PINS Reference: EN010079

14th January 2019

WDC comments on Norfolk Vanguard Offshore Wind Farm

Drawing file: published-documents / EN010079-001743-Figure 12.08 Concurrent Piling Based on Worst Case Scenario.pdf

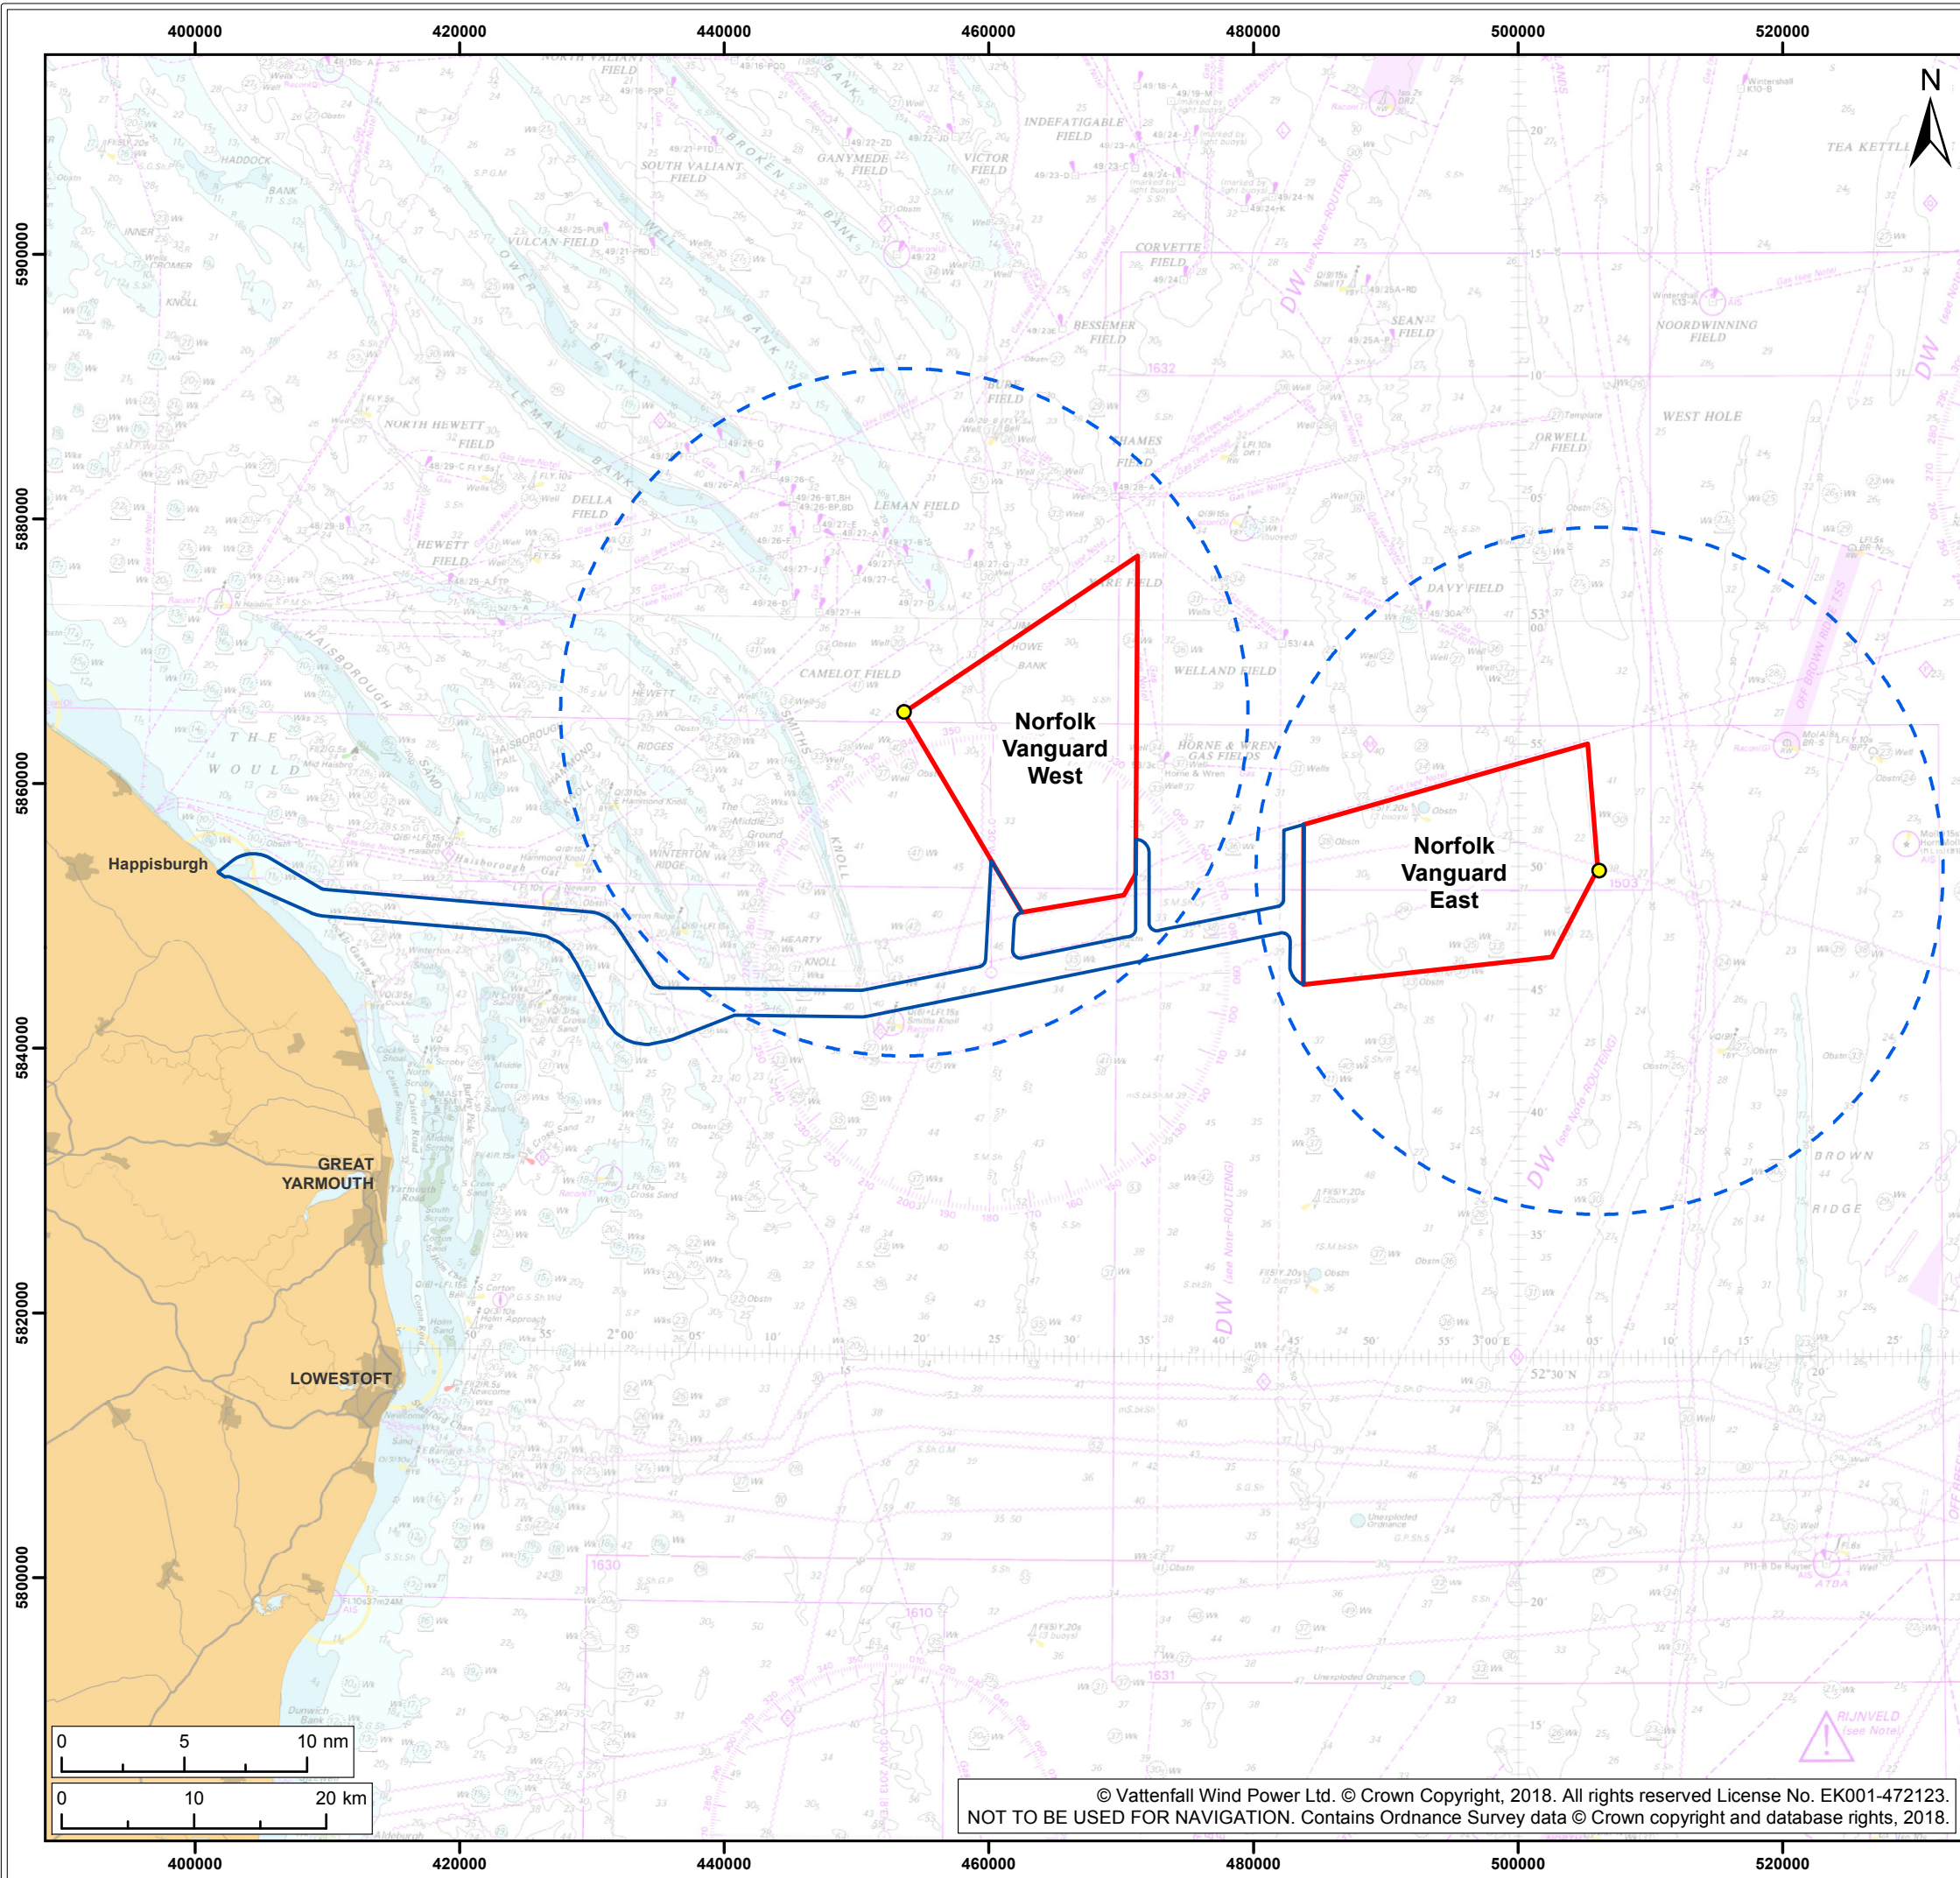
WDC note that there could be two vessels driving piles at any one time, and that pile-driving will start at one site, and then continue at another (which may be adjacent to the pile already being driven or in another area of the wind farm). We are concerned that the cumulative impact assessment does not include pile driving commencing at a second location, whilst the first is still being driven. The impact of the second pile driving location on cetaceans is highly dependent upon the location of the second pile-driving site which is likely to have a different potential area of impact to the first.

In addition, having a second pile-driving location will increase the noise levels generated and have a cumulative impact. We recommend that the same consideration is given to marine mammals when the second pile-driving occurs as is given to the first and that it is not assumed that animals have moved out of the area as pile driving has already commenced elsewhere.

We are also concerned that the CIA does not consider the impact of pile driving at two locations during construction of Norfolk Vanguard. Having a second pile-driving location will increase the noise levels generated in the area and have a cumulative impact, and the severity of the impact will depend on the location of the two piling locations.
